# Appeal Decision

**Appeal Ref: APP/R5510/D/23/3315447**

**5 Chapter Close, Uxbridge UB10 9LA**

- The appeal is made under section 78 of the Town and Country Planning Act 1990 against a refusal to grant planning permission.
- The appeal is made by Mrs Sachita Narain against the decision of the London Borough of Hillingdon.
- The application Ref 41060/APP/2022/3074, dated 7 October 2022, was refused by notice dated 1 December 2022.
- The development proposed is a part first floor rear extension.

RIGHT SIDE ELEVATION
PROPOSED

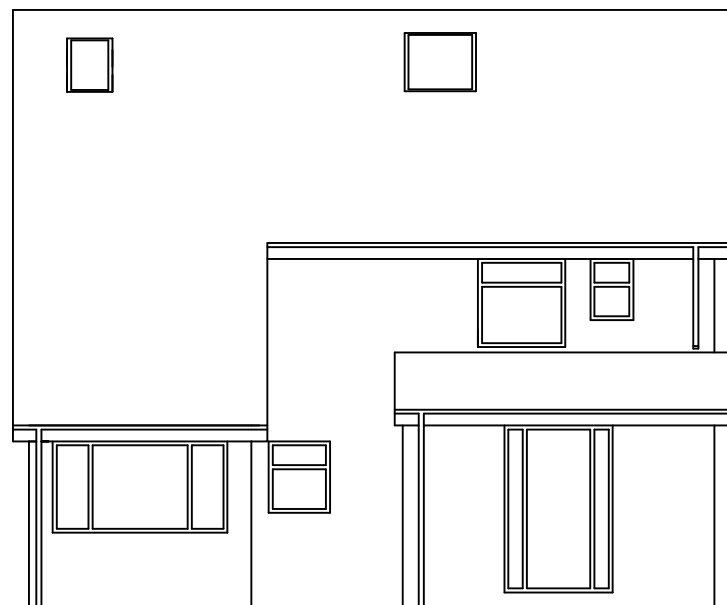
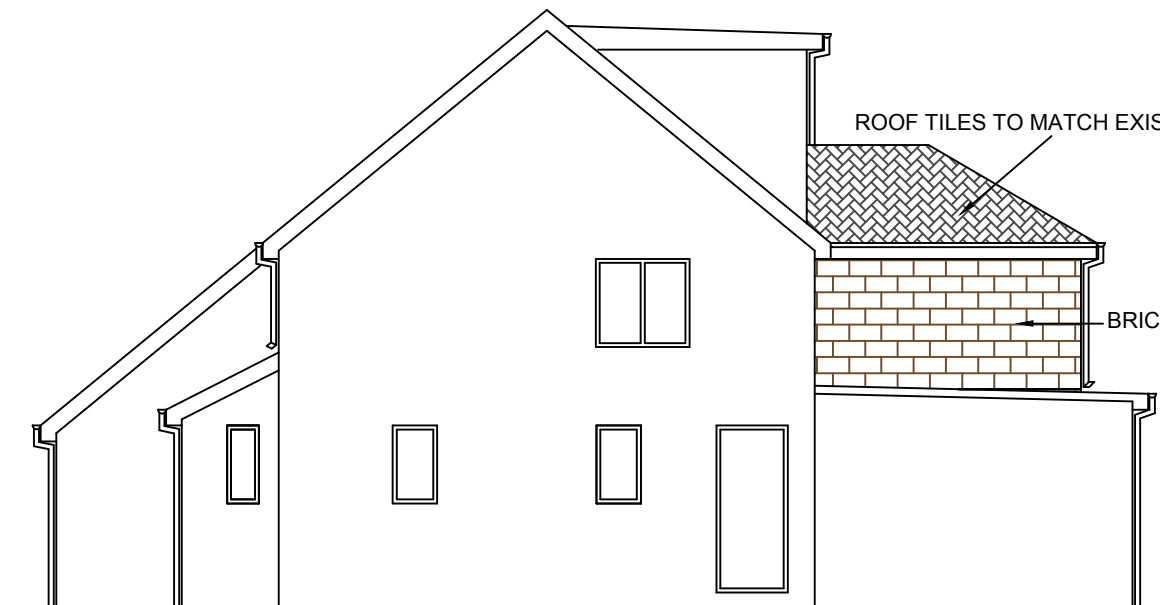
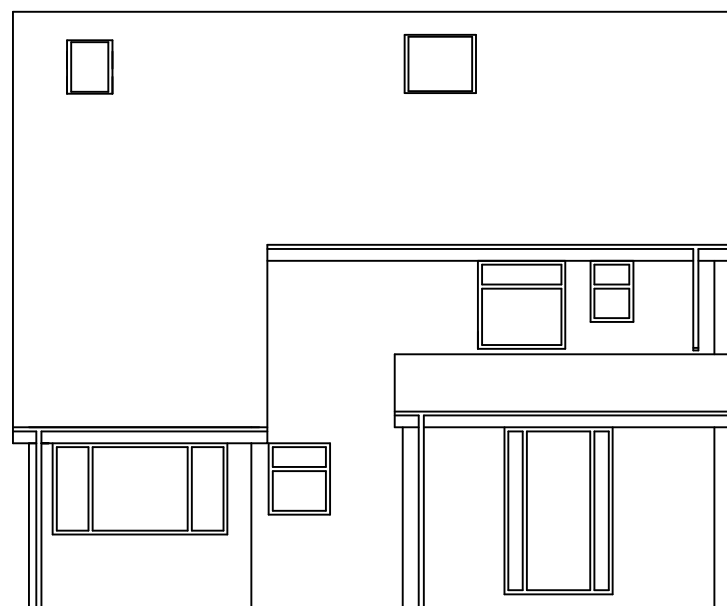
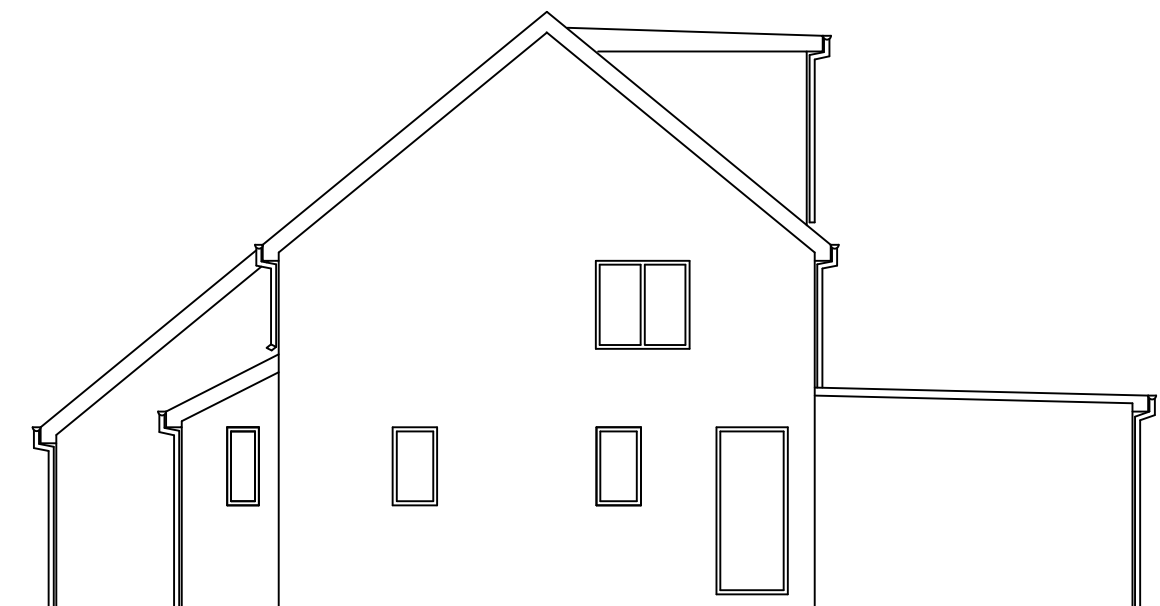
5. Whilst the development is to the rear, the bulk of the projection and the relationship with the dormer window would be seen in views of the side elevation from Chapter Close. The rear elevation is also visible from Hercies Road where the first-floor extension would be an intrusive and incongruous feature, further drawing attention to the property and the rear composition which would be out of keeping with the prevailing pattern of development.

REAR ELEVATION
PROPOSED

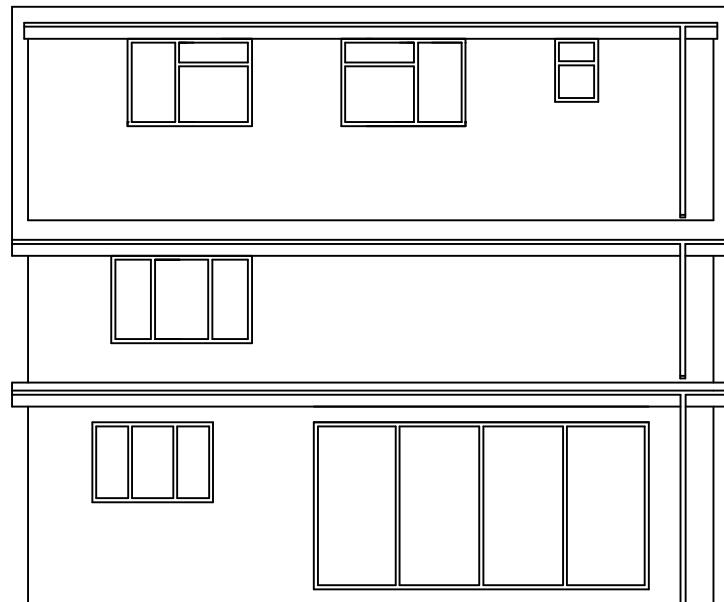
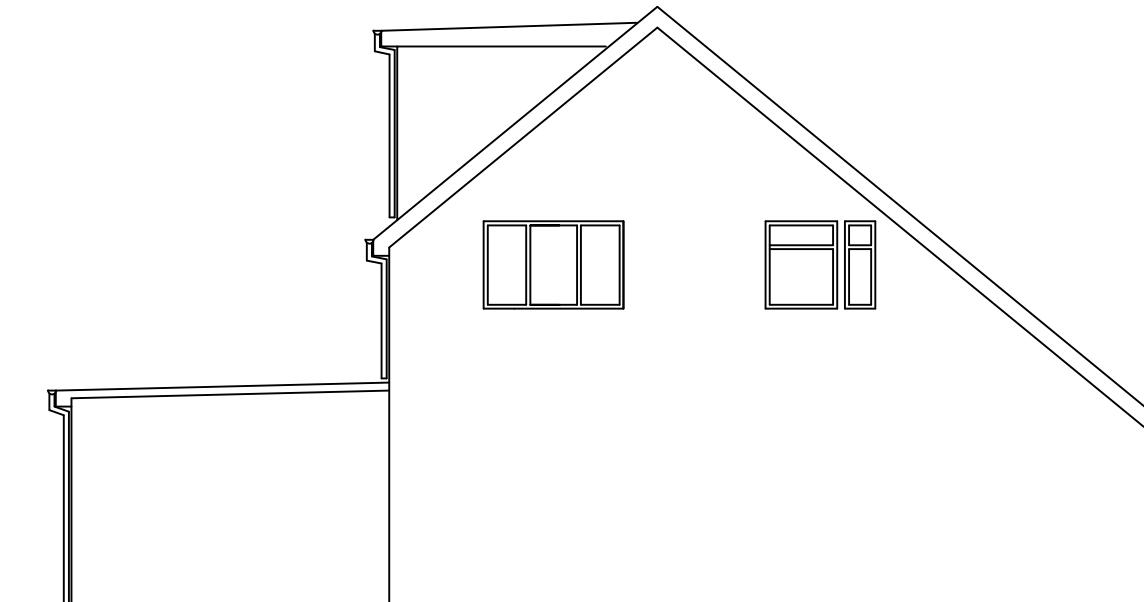
4. The extension would sit above part of the single-storey extension. It would not extend the full depth, but the pitched roof would project over part of the existing dormer with the ridge positioned just below the bottom of the windows. This would create a cluttered and inharmonious arrangement which together with the existing alterations would not reflect the appearance of the original property and consume the rear elevation.
